KITITAS COUNTY

MEMORANDUM

TO: Community Development Services
FROM: Public Works Planning Review
DATE: December 20, 2019
SUBJECT: Horish BL-19-00022

Site Plan

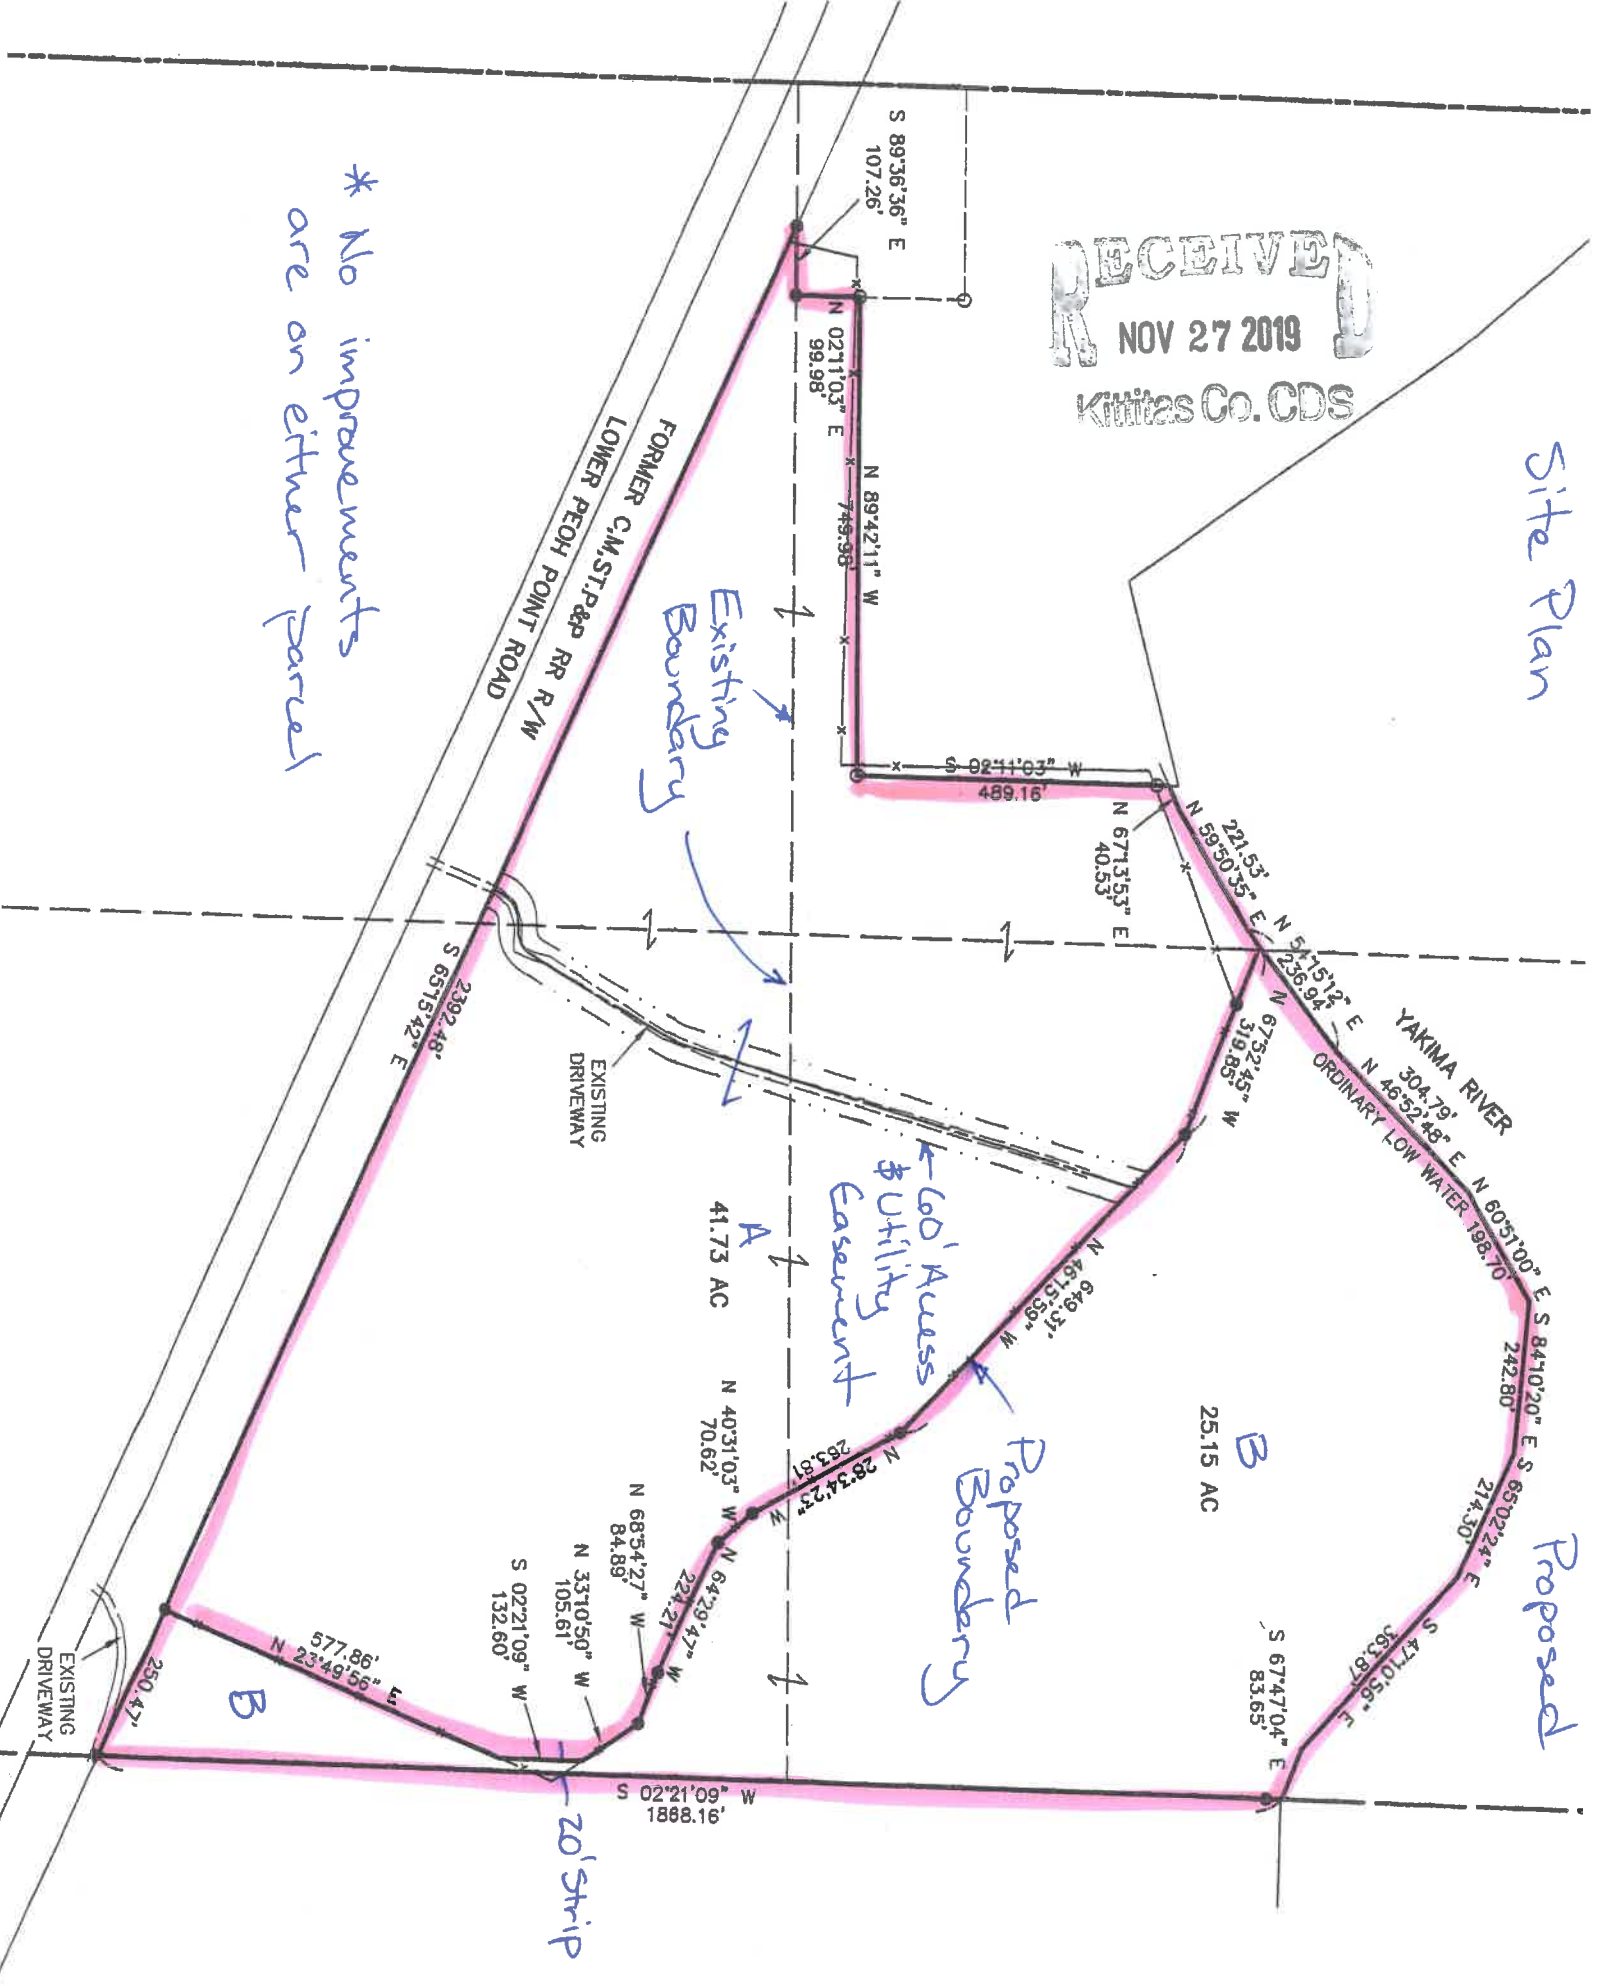
1. A revised legal description that describes the final configuration of the subject property shall be required.
2. A survey map for review
3. Show access easements on the face of the BLA

The proposed BLA does not include a survey map for review. Any comments will be reserved for final.
